Addendum No. 1

RE: Contract ID: C202150

Granville County (B-4524) Proposal No. 2

Bridge Over Shelton Creek And Approaches On SR-1309 (Ben Thorpe Road)

STATE OF NORTH CAROLINA
 DEPARTMENT OF TRANSPORTATION
 RALEIGH
GENERAL DRAWING
 FOR BRIDGE OVER SHELTON CREEK ON SR 1309
 (BEN THORPE ROAD) BETWEEN SR 1315 & SR 1316

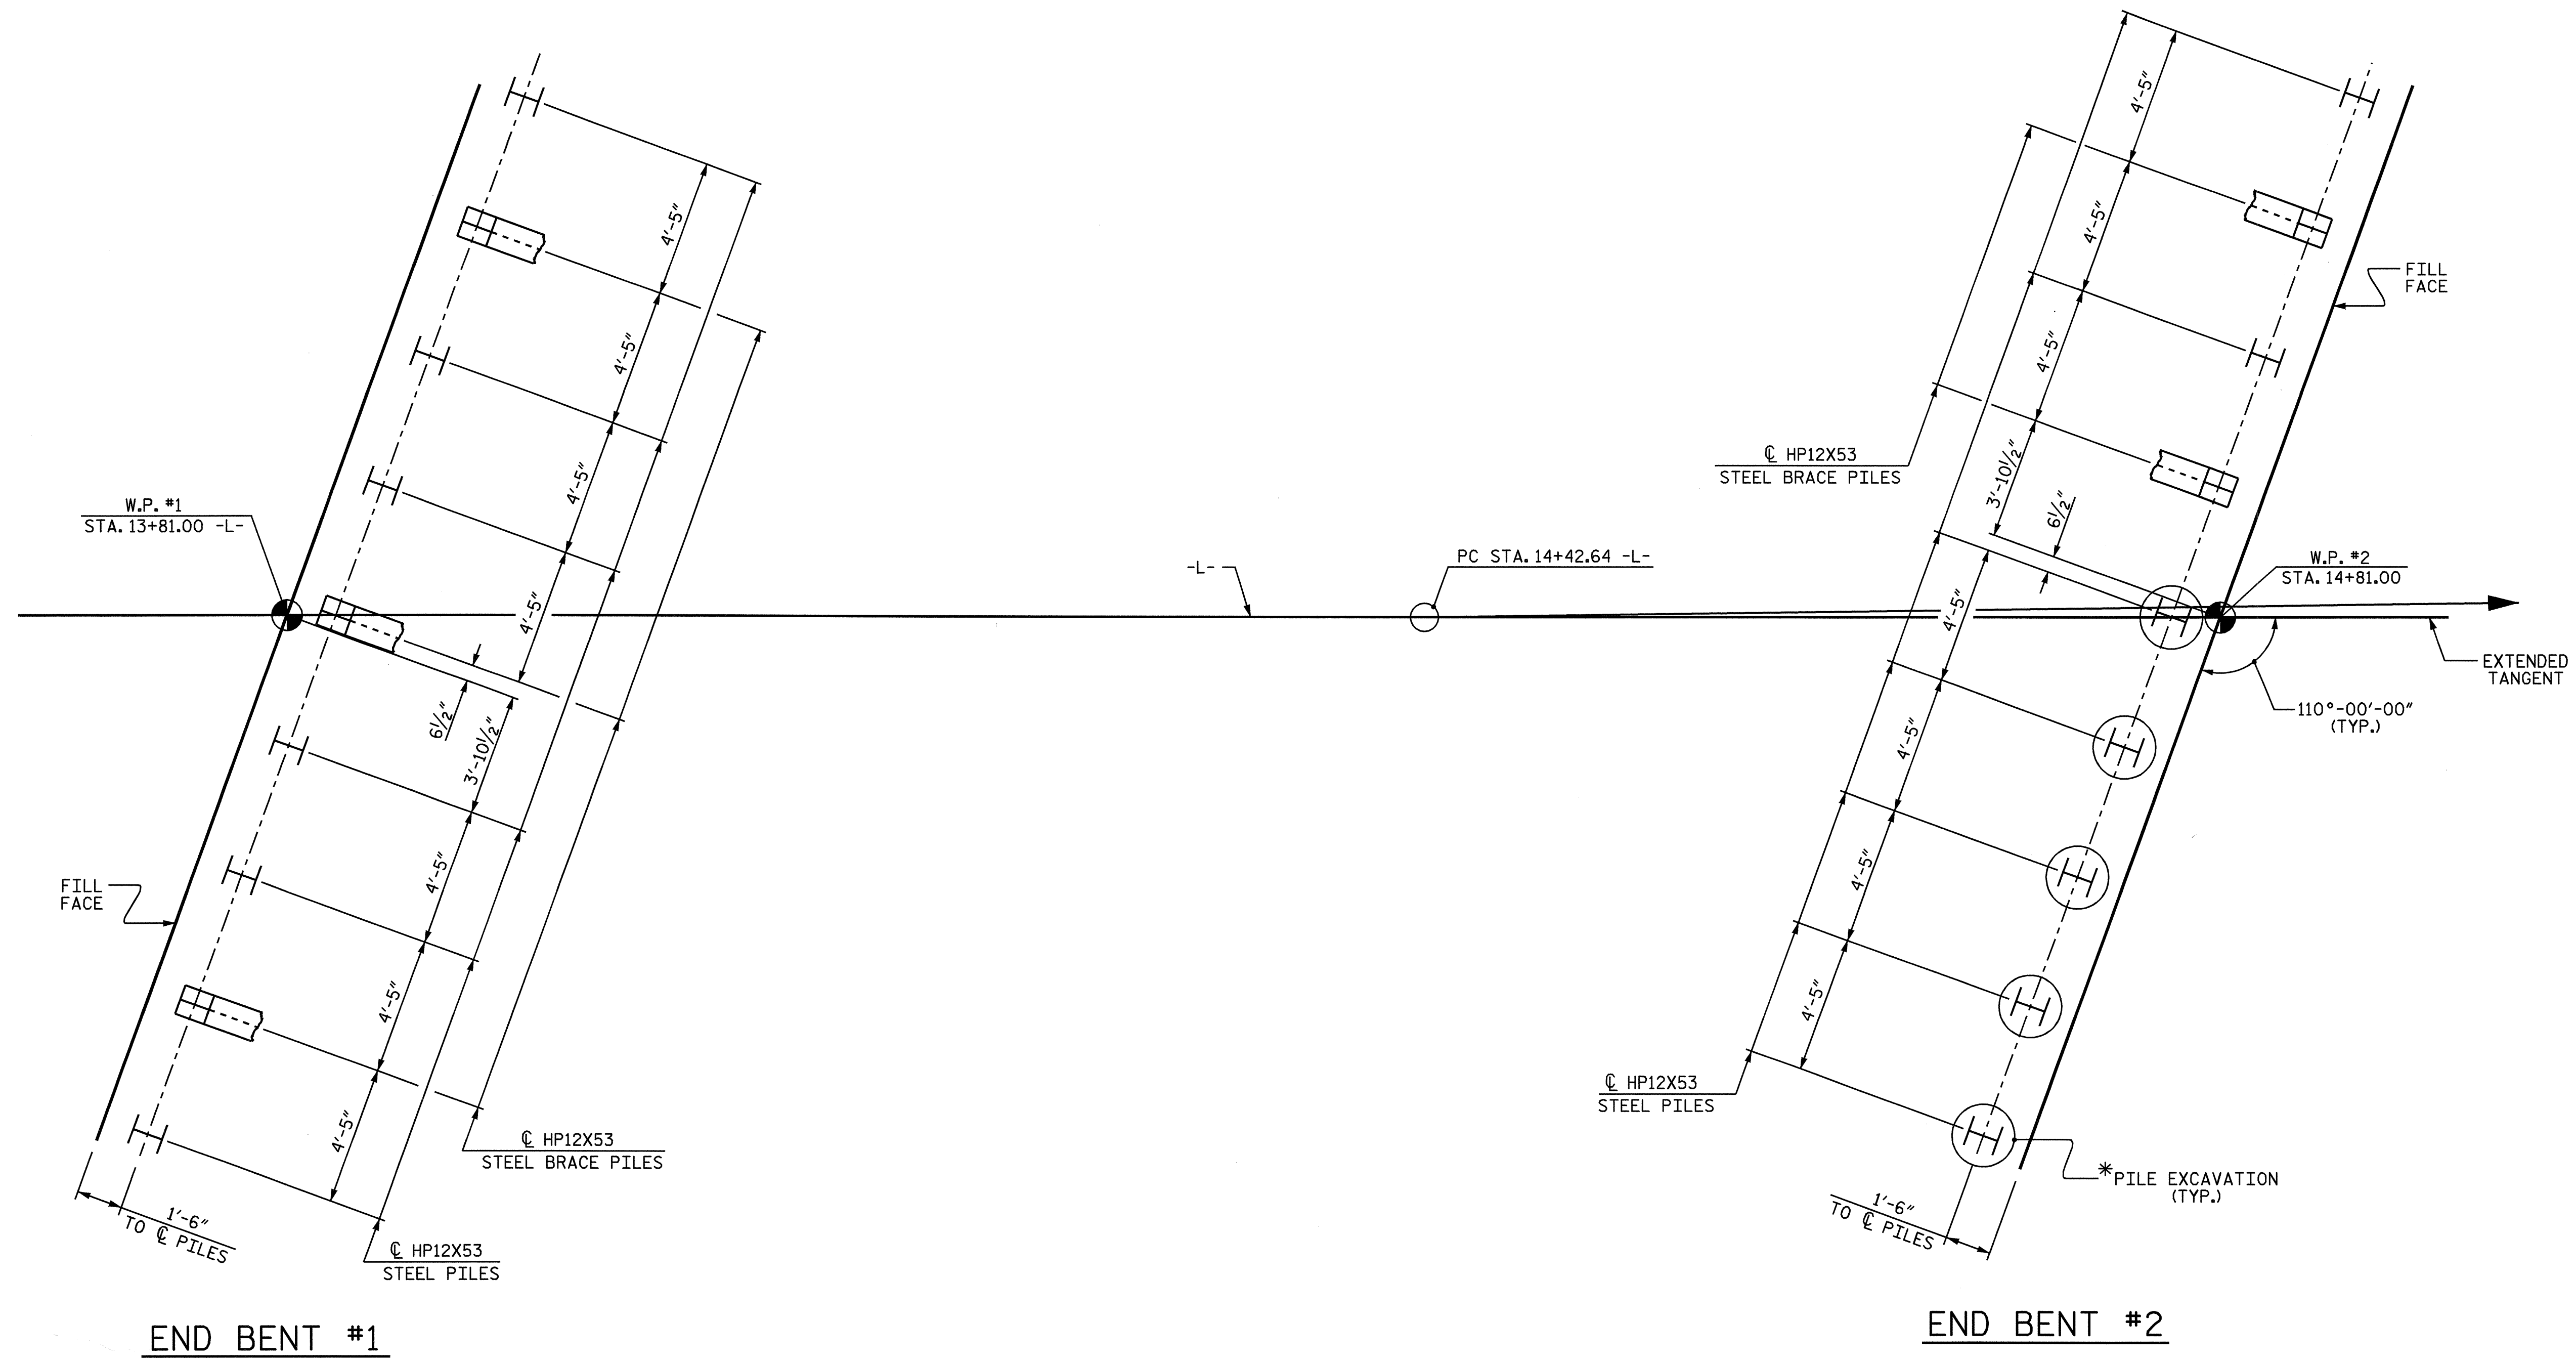
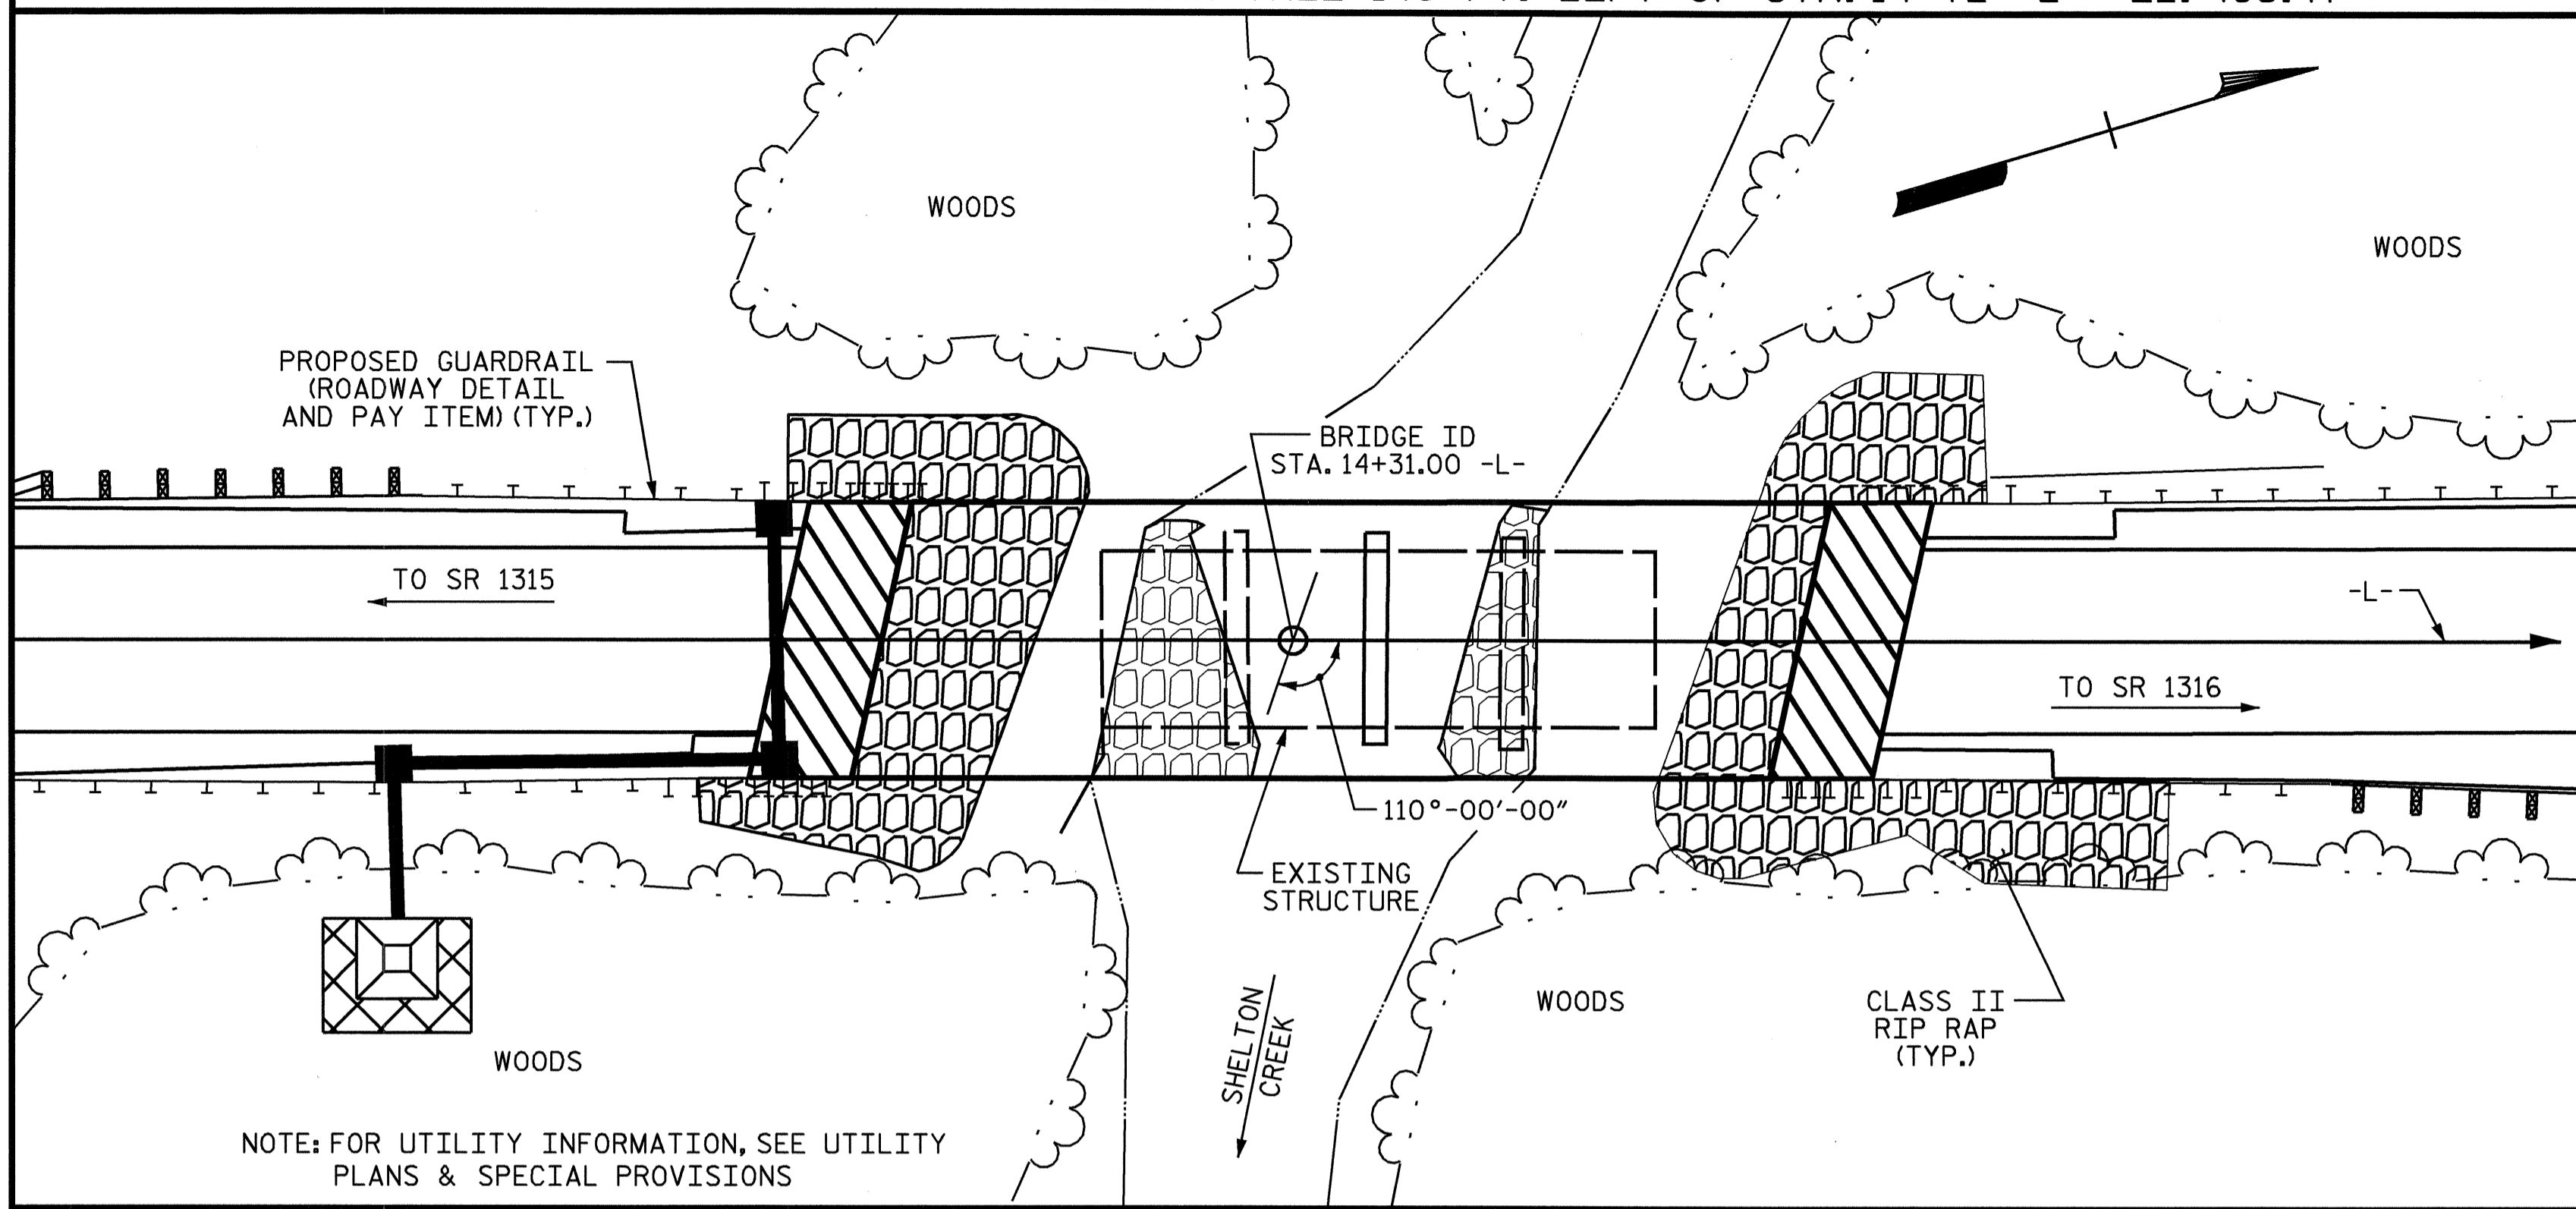
On Page No. 93, the project special provision entitled "Removal Of Existing Structure At Station 14+31.00-L-" has been revised. Please void Page No. 93 in your proposal and staple the revised Page No. 93 thereto.

The existing timber deck and timber joists shall be removed and salvaged for the Division of Highways as directed by the Engineer. The existing asphalt wearing surface shall be removed without damaging the existing timber deck. The timber decking material and joists shall be removed resulting in individual pieces of lumber. The timber decking and joists are to be delivered by the Contractor to the Oxford Bridge Maintenance Yard. One week prior to delivery the Contractor shall notify the Oxford Bridge Maintenance yard at (919) 693-6803. Upon delivery, NCDOT Bridge Maintenance forces will unload the material. The Contractor shall not use any of the items, either temporarily or permanently, which have been removed and are to be salvaged.
